General Permit SWPPP Inspection

Site Name:	<u>Valle De Atrisco</u> <u>10010 Ceja Vista Rd, Albuquerque, NM 87121</u>	Inspector:	Jeff Hart
Permit #:	NMR1001TW NMR1001TV	Inspection Frequency:	Bi-weekly -
Date of Visit:	Jun 4, 2021, 11:46:07 AM	Last Rain Event Tuesday, June 1, 2021, 0.0"	Last Precipitation Friday, June 4, 2021, 0.07" 48h Forecast 19% Chance of Rain

VALLE DE ATRISCO
EROSION & SEDIMENT CONTROL PLAN

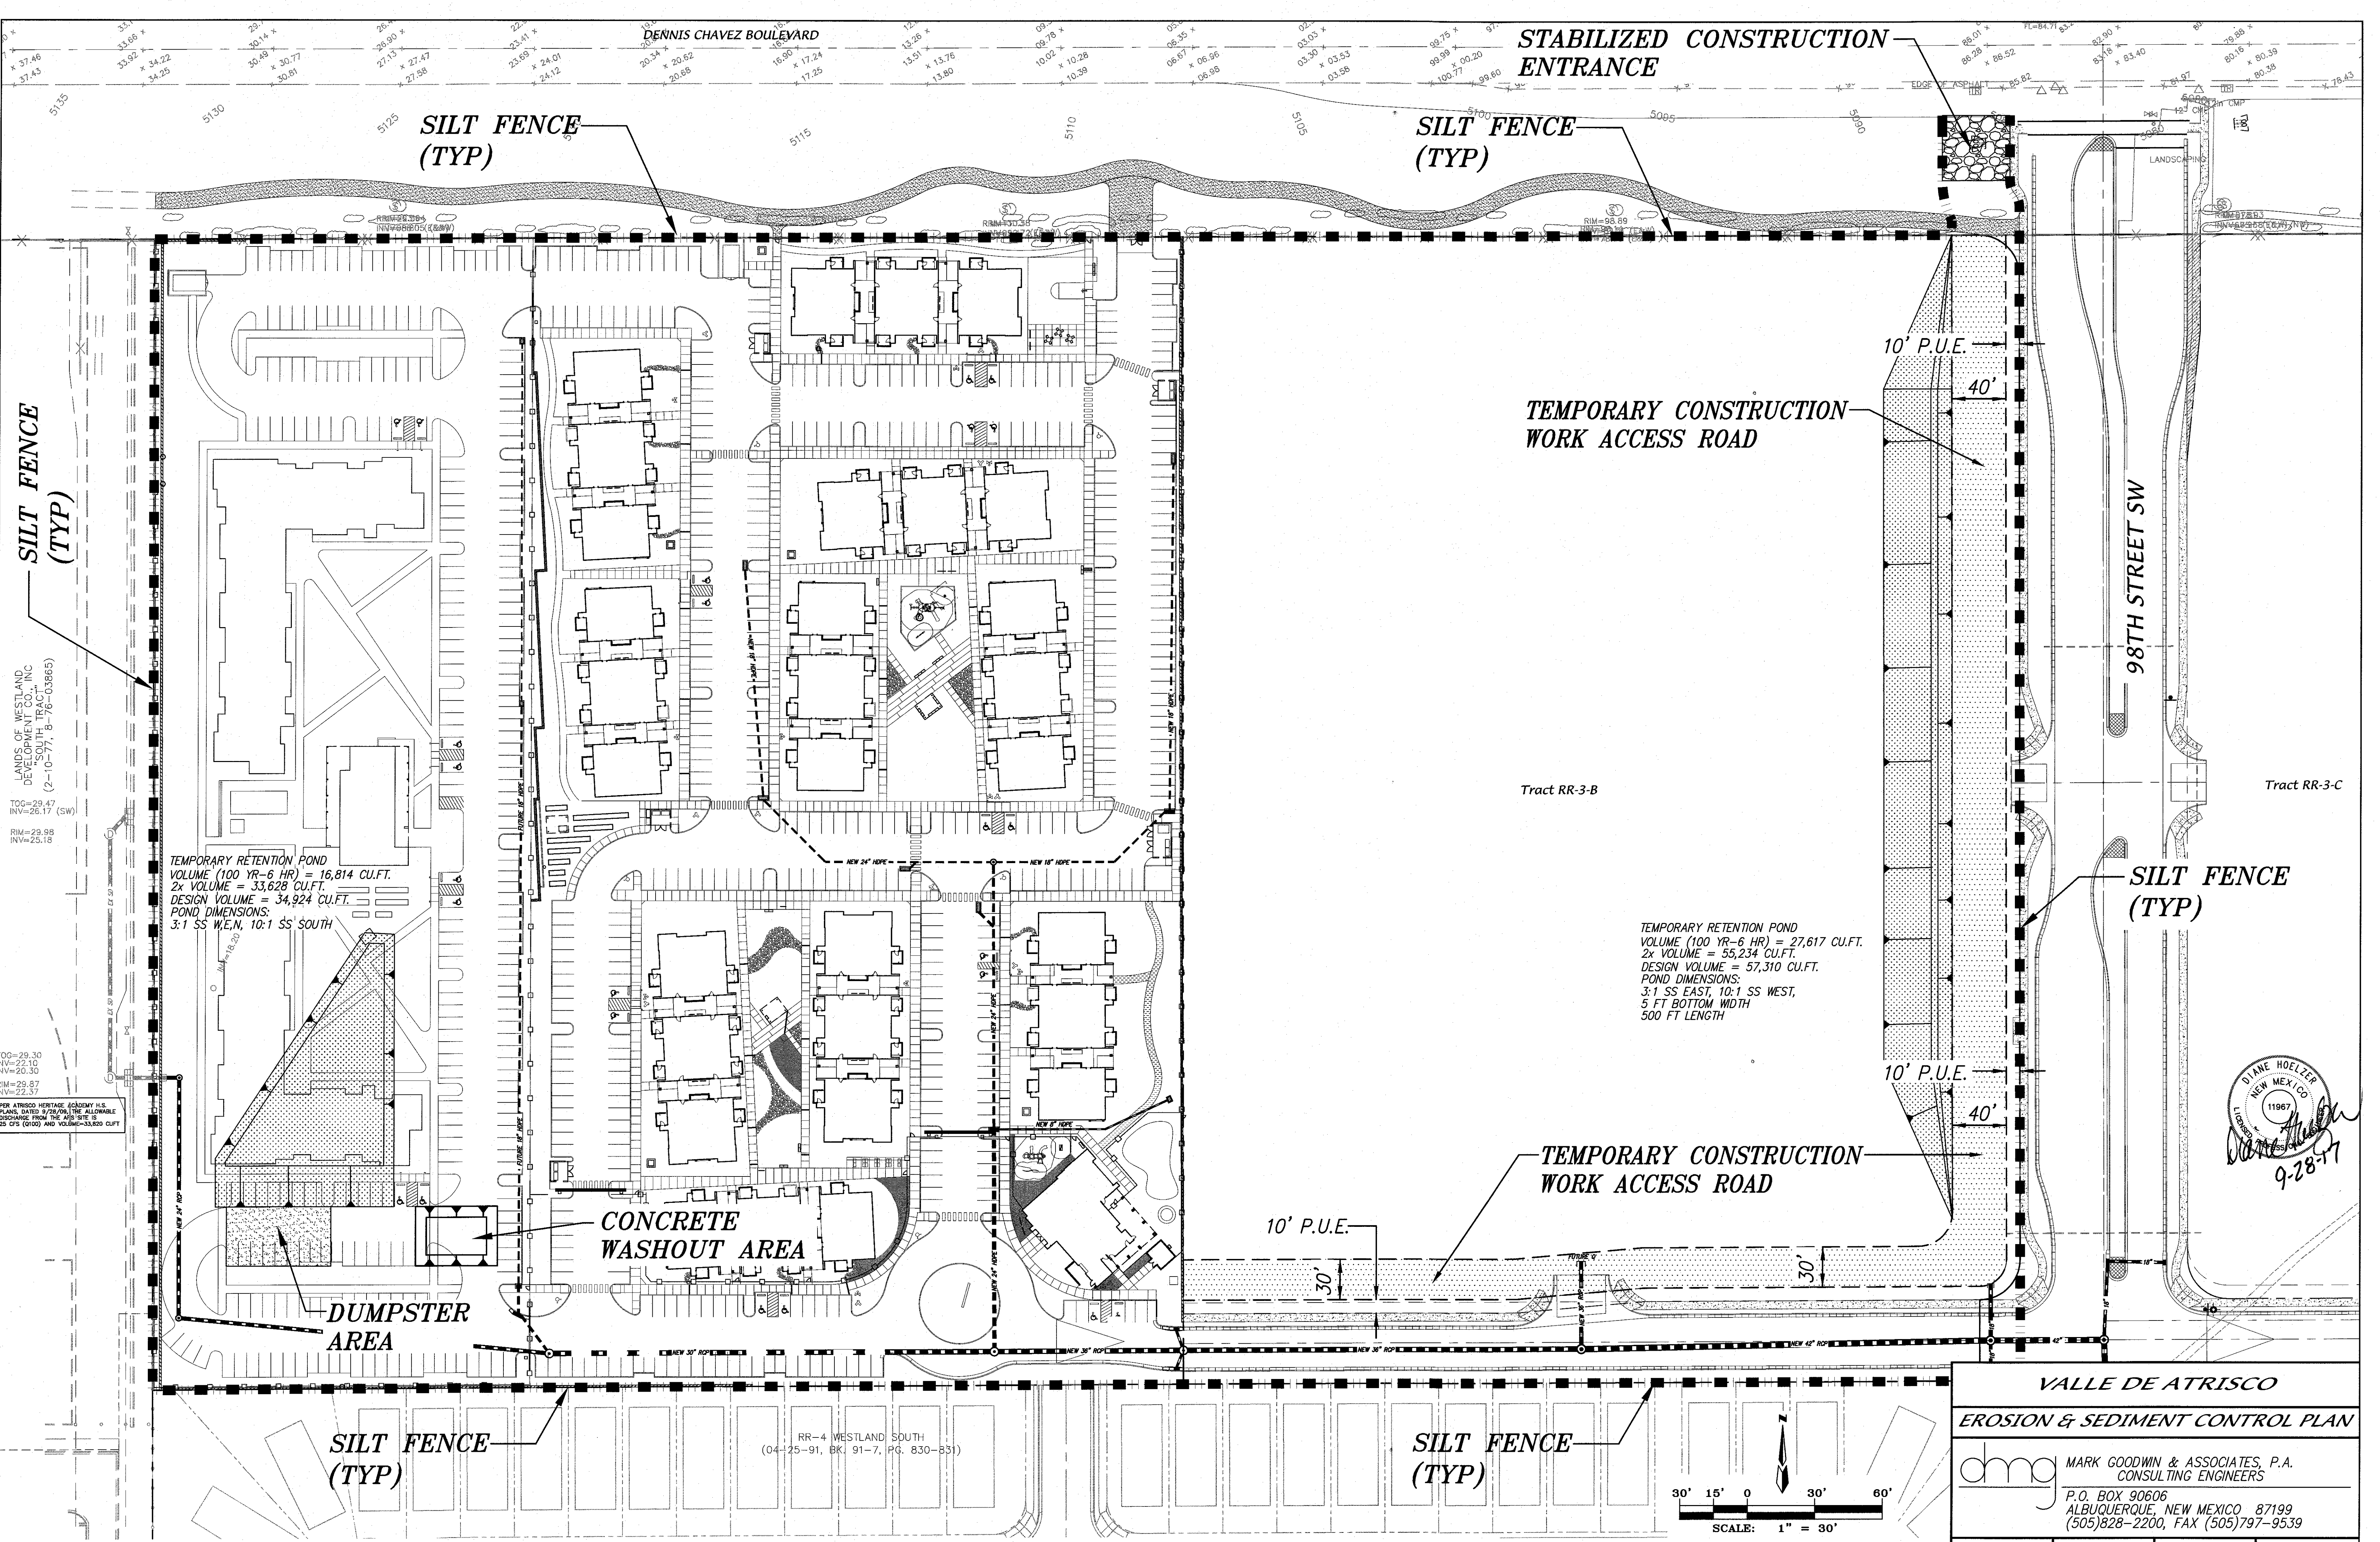
Repair drop inlets at the intersection of Ceja Vista and 98th St. as designated in the SWPPP plan design. Construction debris at the north end of RR-3-B1 requires collection and placement in the designated facility. Silt fence repairs required along RR-3-B1, south end. Southwest ponding location requires silt fence install and maintenance per the ECP. Rip rap at southwest pond, where swale meets rock, shown large riffs in the berm. Repair earth berm and correlating silt fence.

Drop Inlet protection and maintenance of existing inlets are required as prescribed by the SWPPP plan. Southwest ponding location requires silt fence install and maintenance per the ECP. Rip rap at southwest pond, where swale meets rock, shown large riffs in the berm. Repair earth berm and correlating silt fence. No changes to the SWPPP document at this time.
